Subject: SP-25-00006 Deatherage - Notice of Application

TO: All Staff
FROM: Public Works Plan Review Team
DATE: May 13, 2025
SUBJECT: SP-25-00006 Deatherage

To: All Staff
From: Environmental Health
Date: May 14, 2025
Subject: SP-25-00006

RE: 202501773; SP-25-00006

DEATHERAGE SHORT PLAT  
 PART OF SECTION 34, T. 18 N., R. 19 E., W.M.  
 KITTITAS COUNTY, WASHINGTON

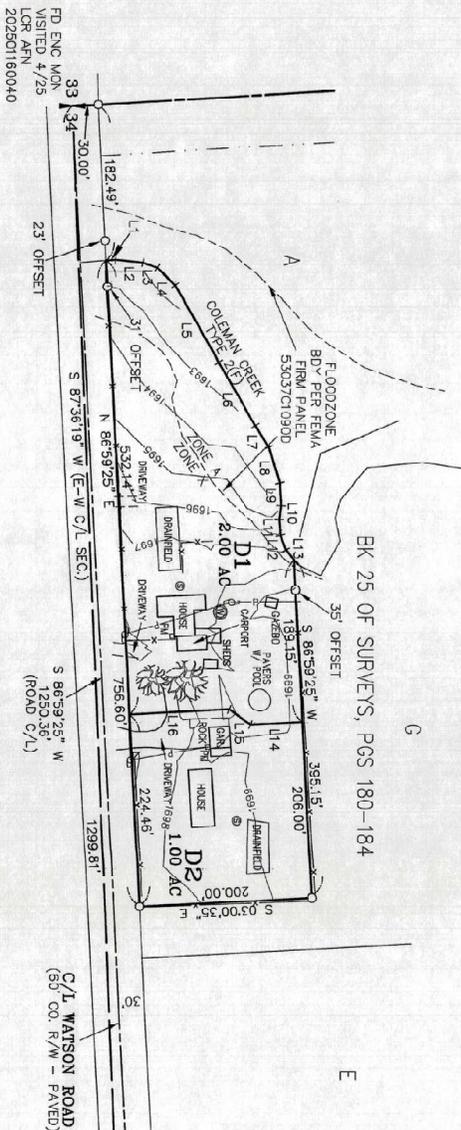
| SURVEY | <p>There are no proposed revisions to this prelim Short Plat.</p> <p>For final, the following will need to be addressed:</p> <ol style="list-style-type: none"> 1. Property corners to be set 2. Basis of bearing to be addressed 3. Title report will need to be updated showing the legal owner, as this appears to be absent from the report. 4. Fence offsets from property lines to be shown. (JT) |
